# CITY OF ALBUQUERQUE

**RE: Lot 2 Block 2, Unit 22 Volcano Cliffs  
6612 Petirrojo Rd NW  
Grading and Drainage Plan  
Engineers Stamp Date 3/17/15 (D10D003G1)**

**RE: Lot 1, 2 Block 2 Unit 18 Volcano Cliffs  
6610 & 6612 Petirrojo Rd NW  
Grading and Drainage Plan  
Engineers Stamp Date 3/13/15 (D10D003G1&2)**

GRADING & DRAINAGE PLAN
6610-6612 PETIRROJO RD NW
LOTS 1-2, BLOCK 2, UNIT 18 VCS

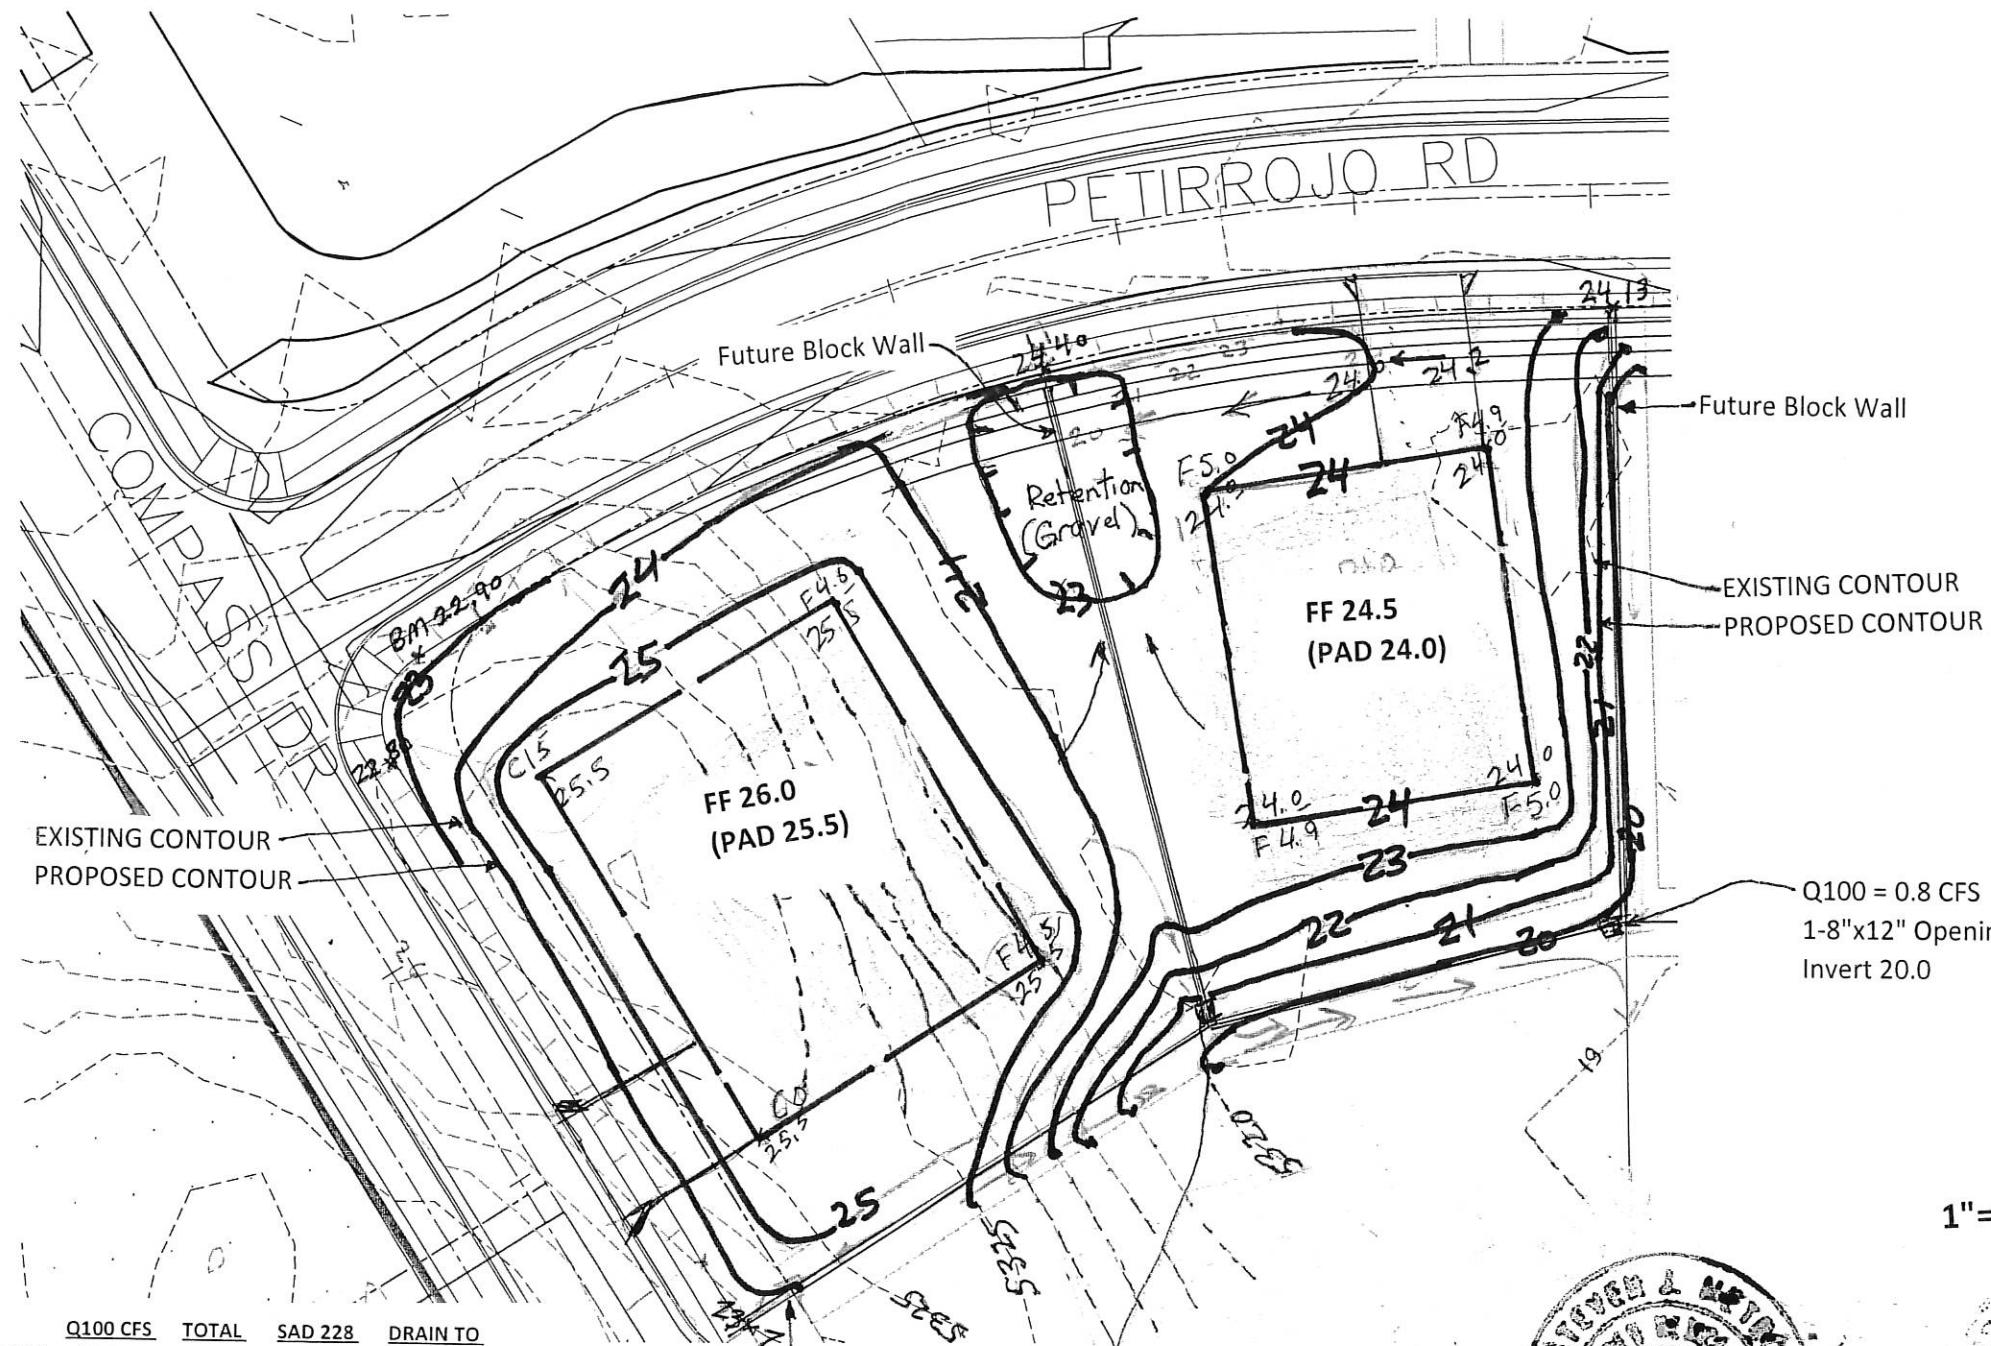
Based upon the information provided in your submittal received 3/13/15, this plan cannot be approved for Grading Permit and Building Permit until the following comments are addressed.

- Separate the two lots into two separate submittals.
- Both lots are to drain out the front yard.
